WAYNFLETE LOWER SCHOOL - ADDENDUM #2

date: Monday, February 06, 2017
project: Waynflete Lower School Addition & Renovations, 2013-0050
prepared by: Austin Smith Scott Simons Architects
to: Cordelia Pitman Wright Ryan Construction
Rick Bergeron Wright Ryan Construction
Luke Dione Wright Ryan Construction
Anne Hagstrom Waynflete School
Patrick Boure Waynflete School
Phil LaClaire PML Project Management

Subject: Addendum #2 to Bid Documents of January 12, 2017

EL500

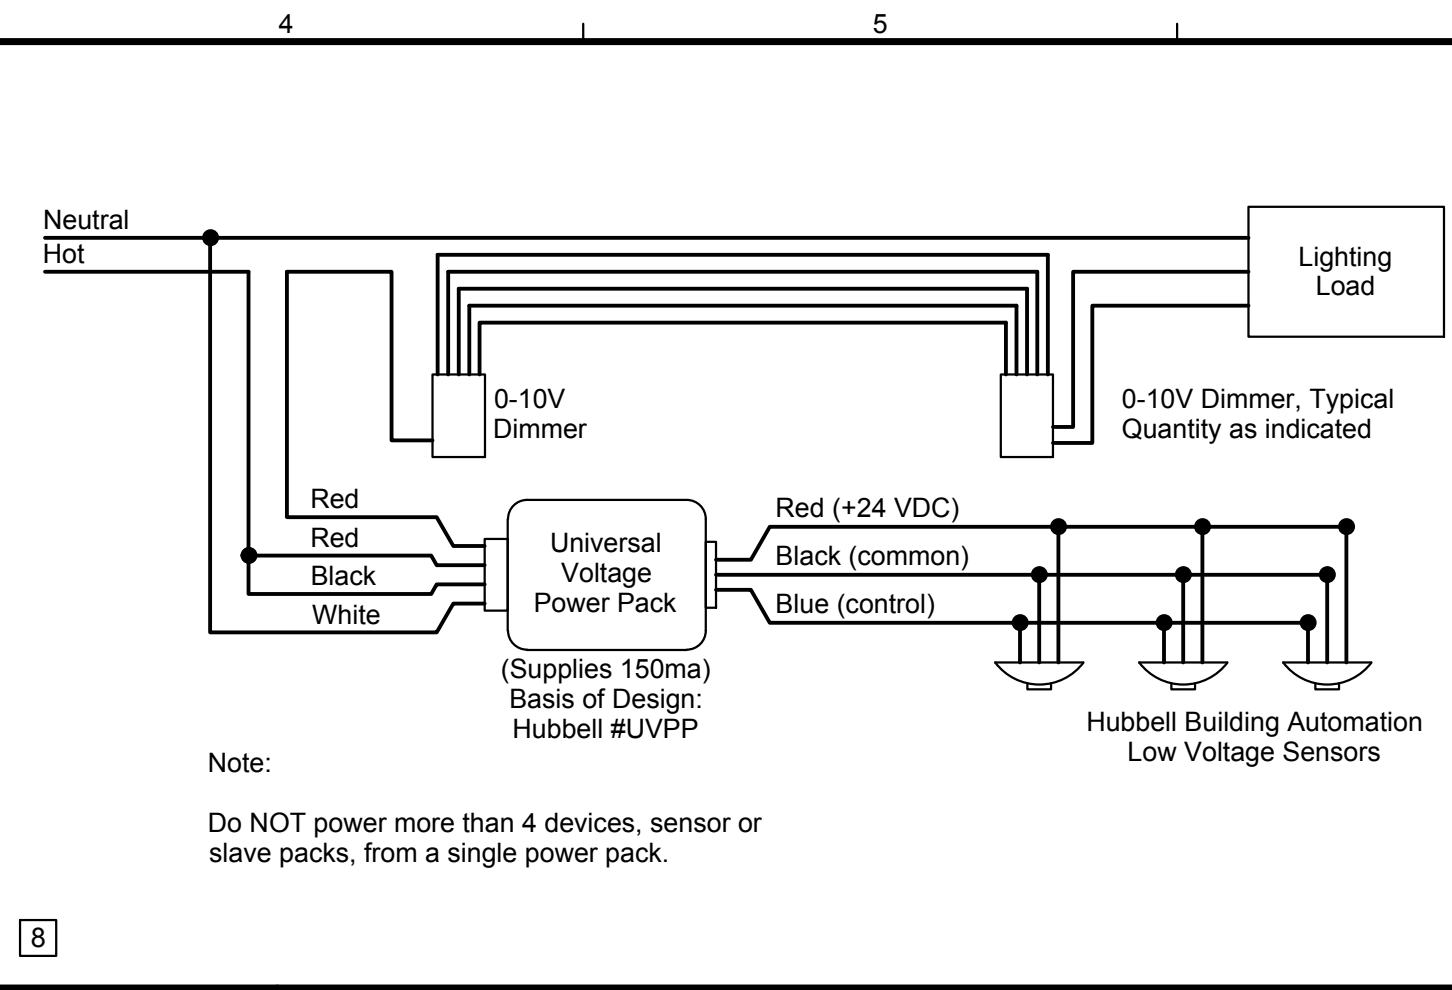
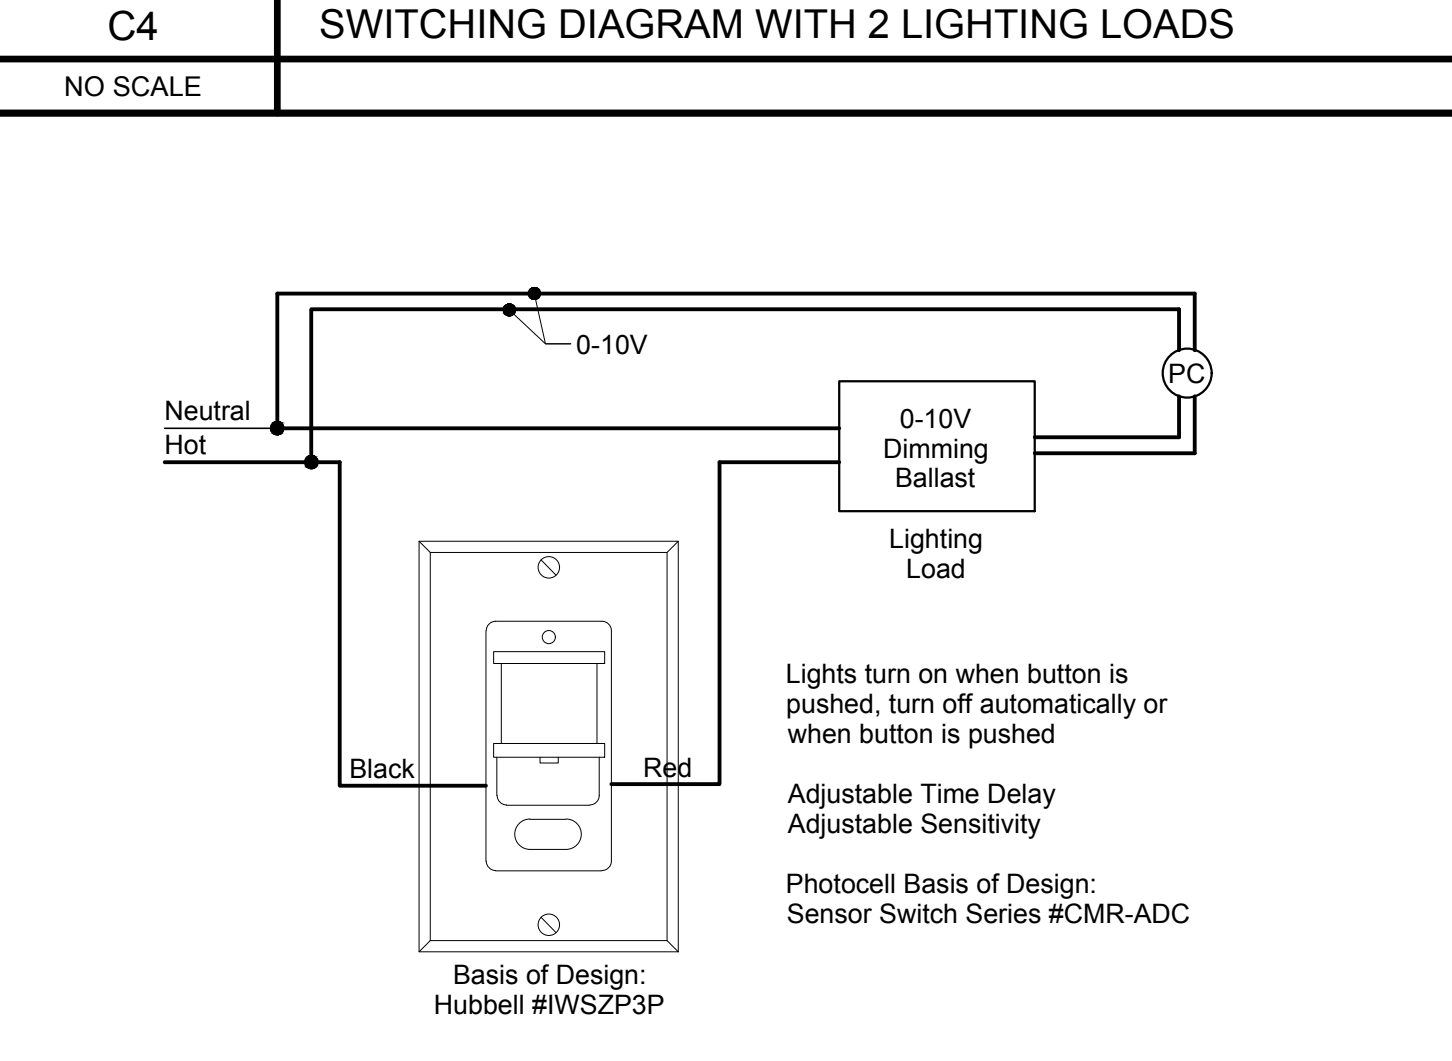
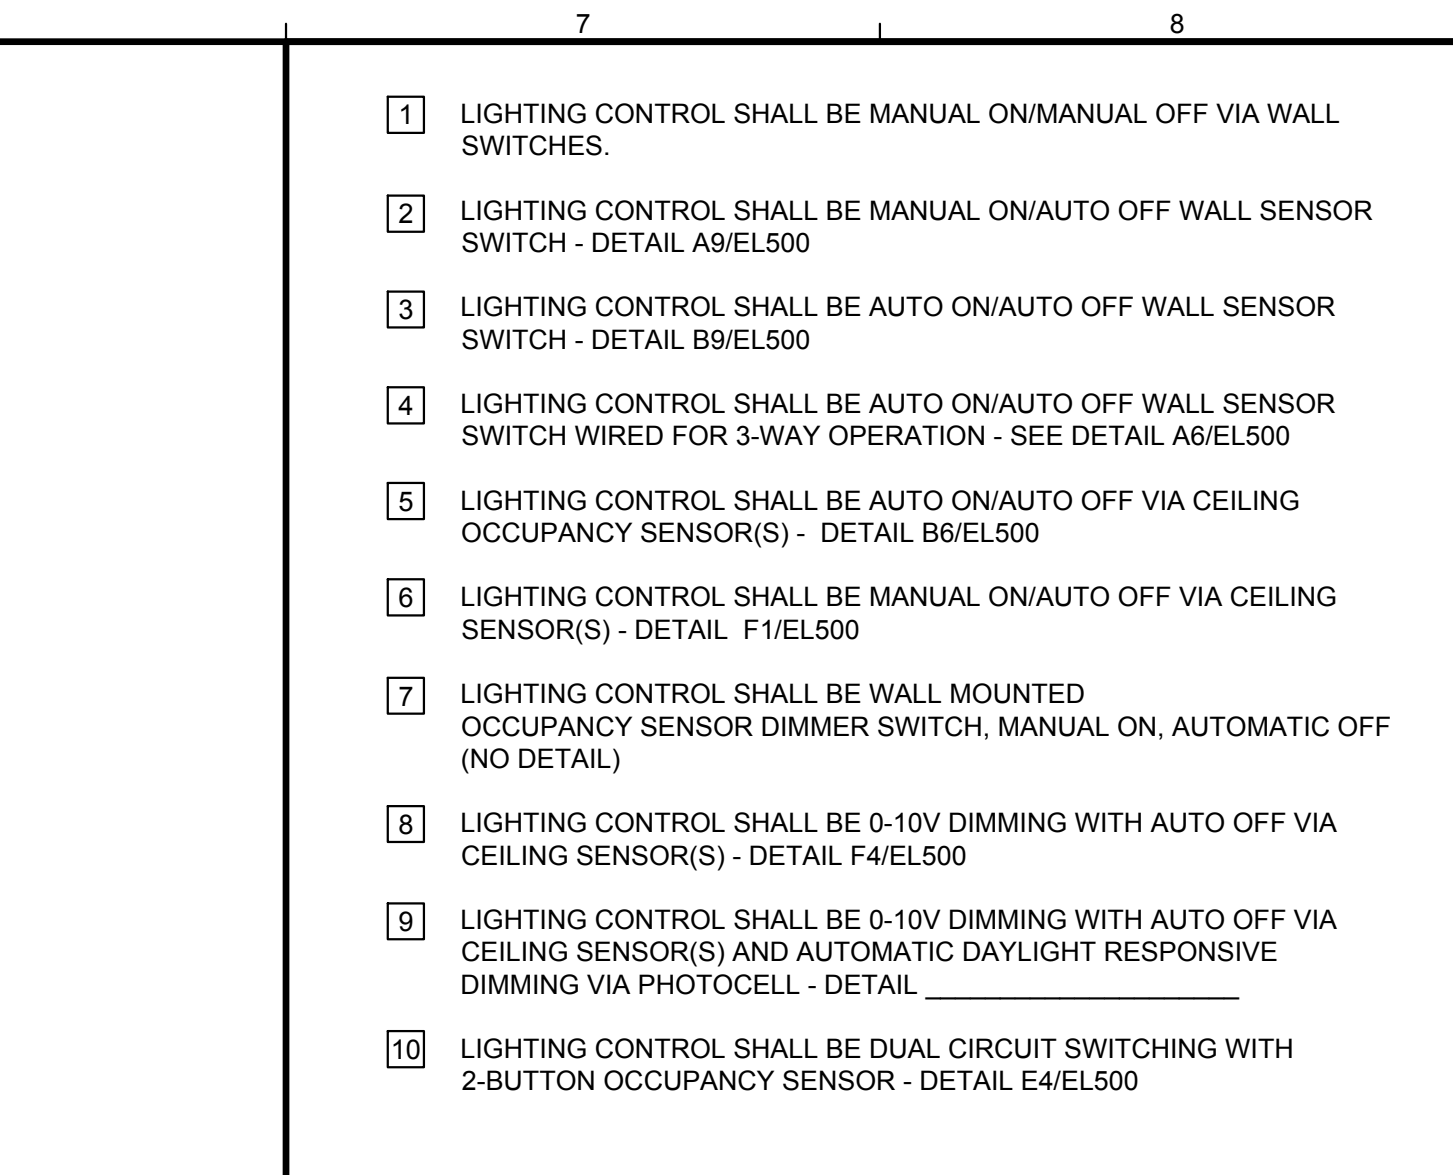
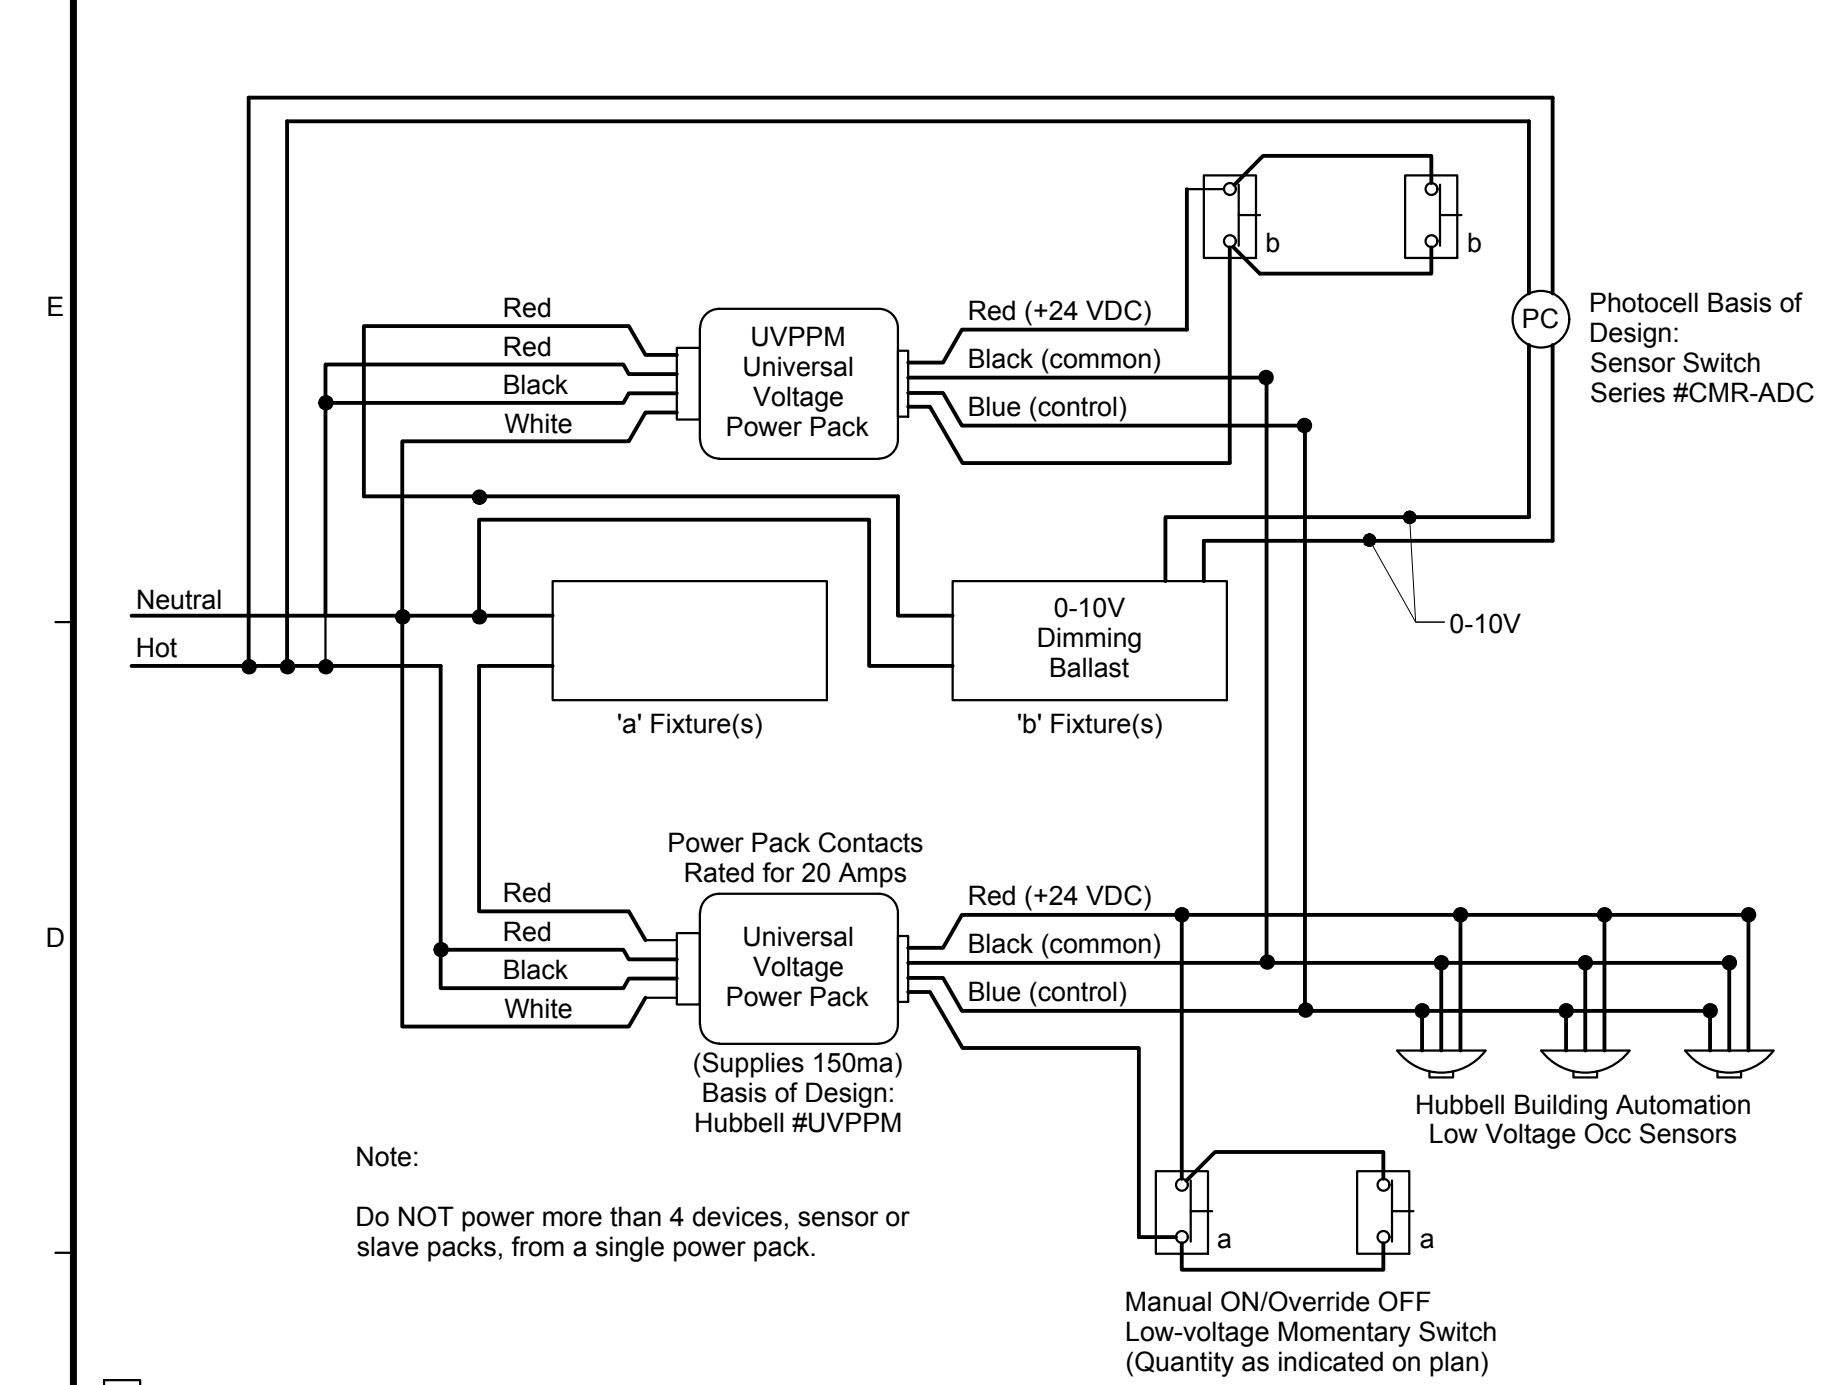
- 2-Q26 Question 26 Dwg I-101 dumpster pad What type of reinforcing is required ?
A: At Dumpster Slab, use #4 reinforcement at 12" OC each way.
- 2-Q27 Questions 27 Q: EL500, there is no wiring diagram detail that corresponds to
Keynote 9. Keynote 9 is used in several locations. Are we to wire room 205
(EL103) as 1 multi-zone room or as 5-6 individual rooms; typical of other
classroom wings?
A: Each separately tagged room with a lighting control note tag shall be wired as
an individual room. Refer to attached revised lighting drawings for further
information.
